**From:** [Kelly Bacon \(CD\)](#)  
**To:** [Val](#)  
**Cc:** [Dan Carlson](#); [Arden Thomas](#); [Holly Erdman](#); [Tristen Lamb](#); [Jeremy Johnston](#); [Stephanie Moore](#); [Sam](#)  
**Subject:** RE: SPF-21-00002 Zipperer - Comments and RFI Compliance  
**Date:** Monday, July 19, 2021 2:29:47 PM  
**Attachments:** [image001.png](#)

Thank you for the requested information. During initial review of the amended Final Short Plat survey, CDS notes substantial changes taking place to lot lines and acreage associated with three of the four parcels. CDS previously agreed to allow minor changes to the lot lines in order to meet the 50' well setbacks. Substantial changes as proposed would require an amendment to the Approved Preliminary Short Plat.

**ZIPPERER SHORT PLAT, SP-20-00005
 SPF-21-00002**

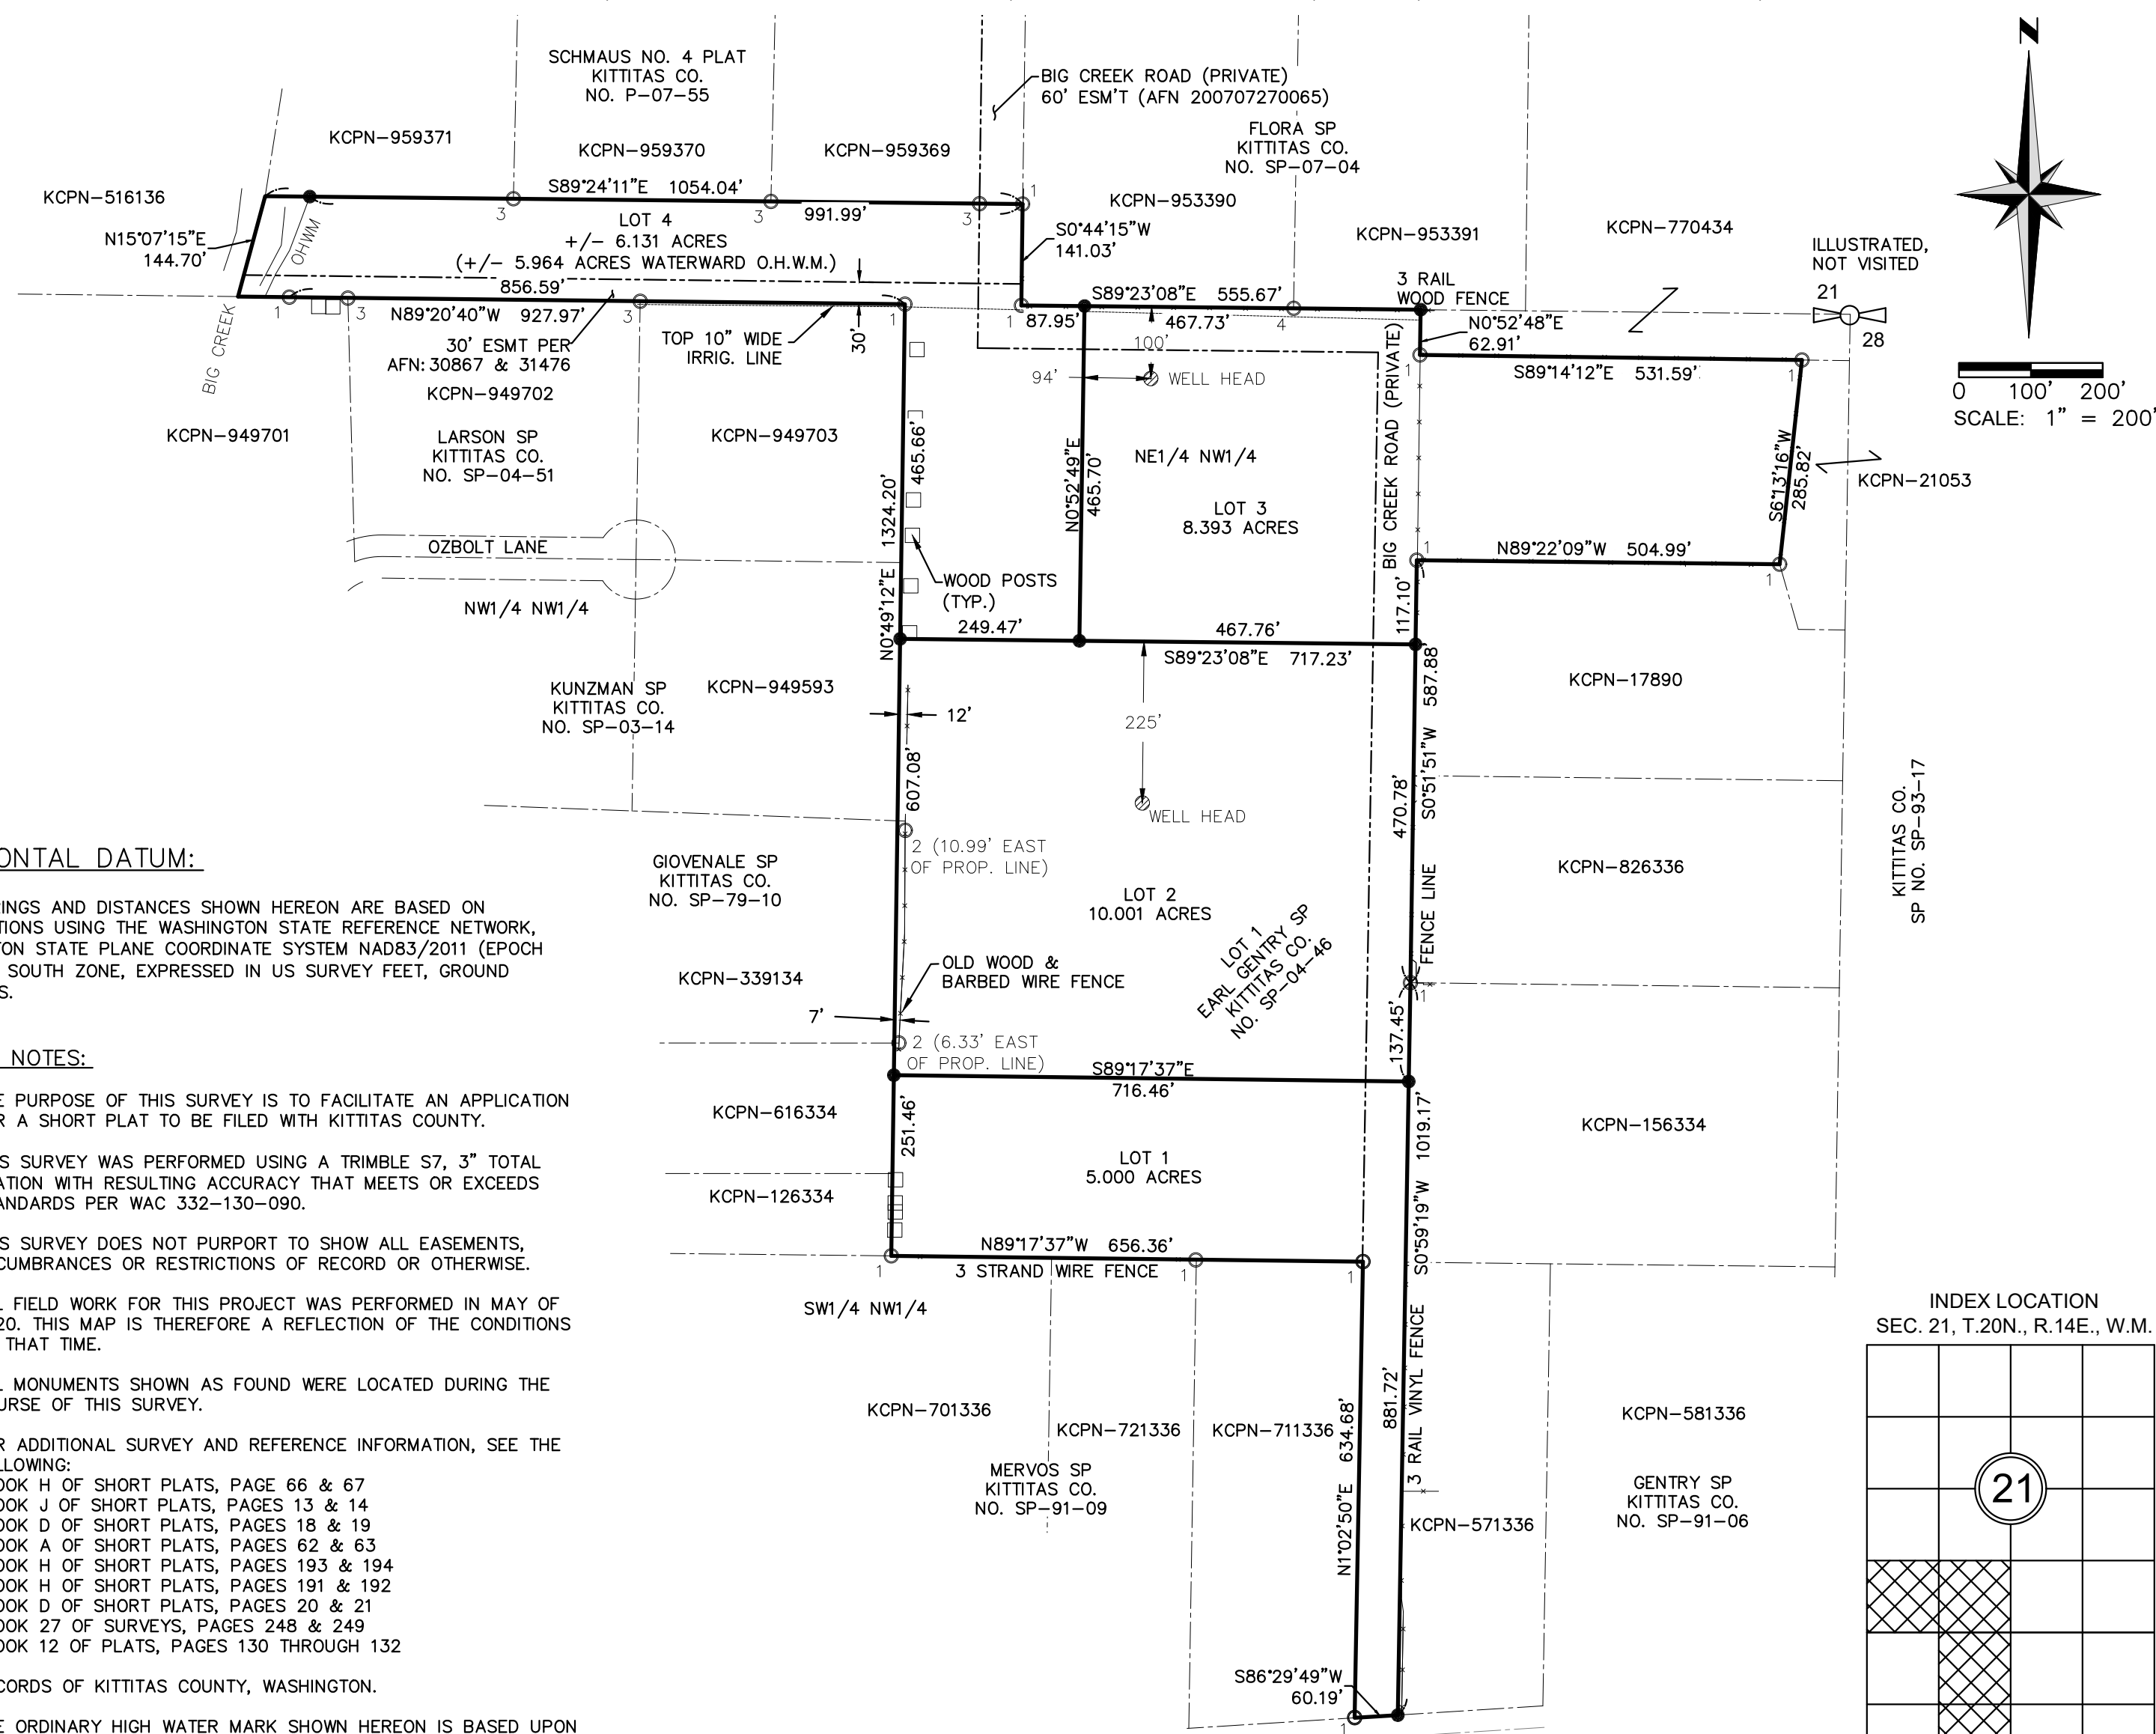
CDS is requesting an updated site map meeting the previously approved preliminary short plat with the acceptance of a few lot lines needing adjustment to meet the 50' minimum well setback or the applicant could choose to move forward with an amendment.
